**3050 N. Curtis Road, MS-19-6**

Please accept the following comments from El Paso County Public Health regarding the project referenced above:

Mike McCarthy  
El Paso County Public Health  
719.575.8602 (O)  
[mikemccarthy@elpasoco.com](mailto:mikemccarthy@elpasoco.com)  
24July2019  
Revised, 31Jan2021

# Wyoming Estates

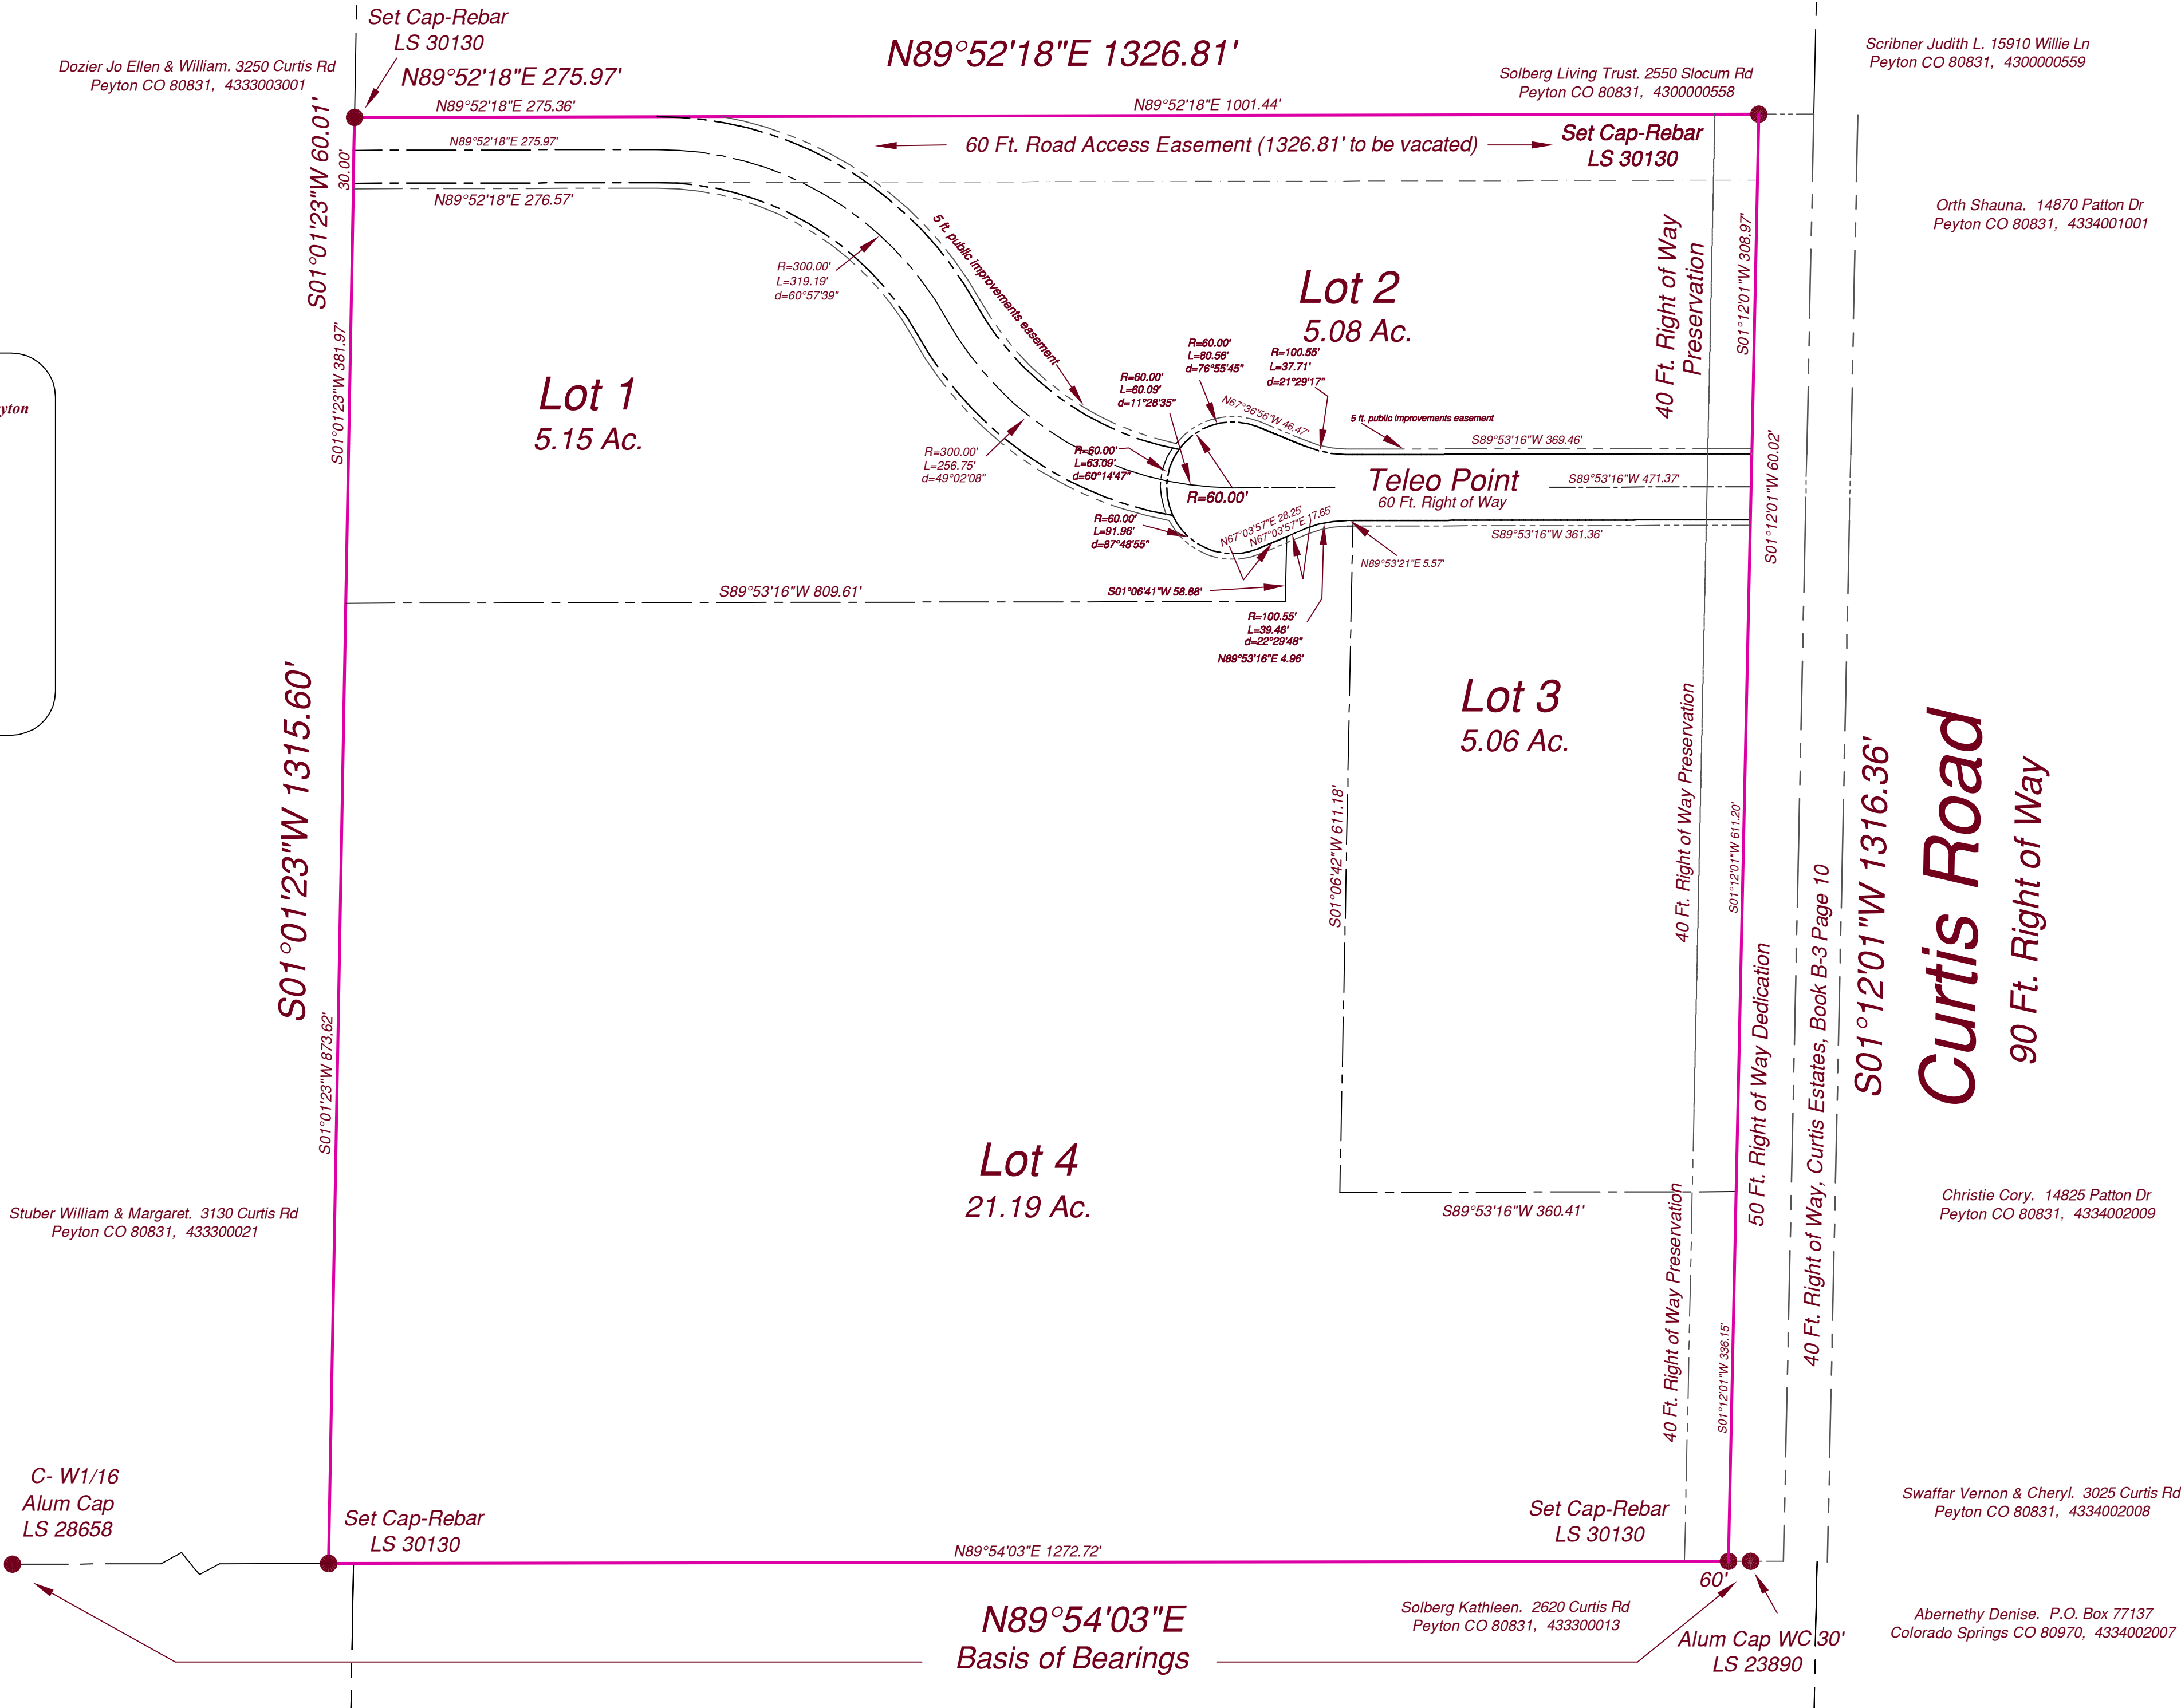
- The proposed new lots require full compliance with the El Paso County Board of Health Regulations, Chapter 8, Onsite Wastewater Treatment Systems.
  - Adjacent property well locations were not shown; therefore, be aware of the specific 100'+ setback requirements to exterior wells.
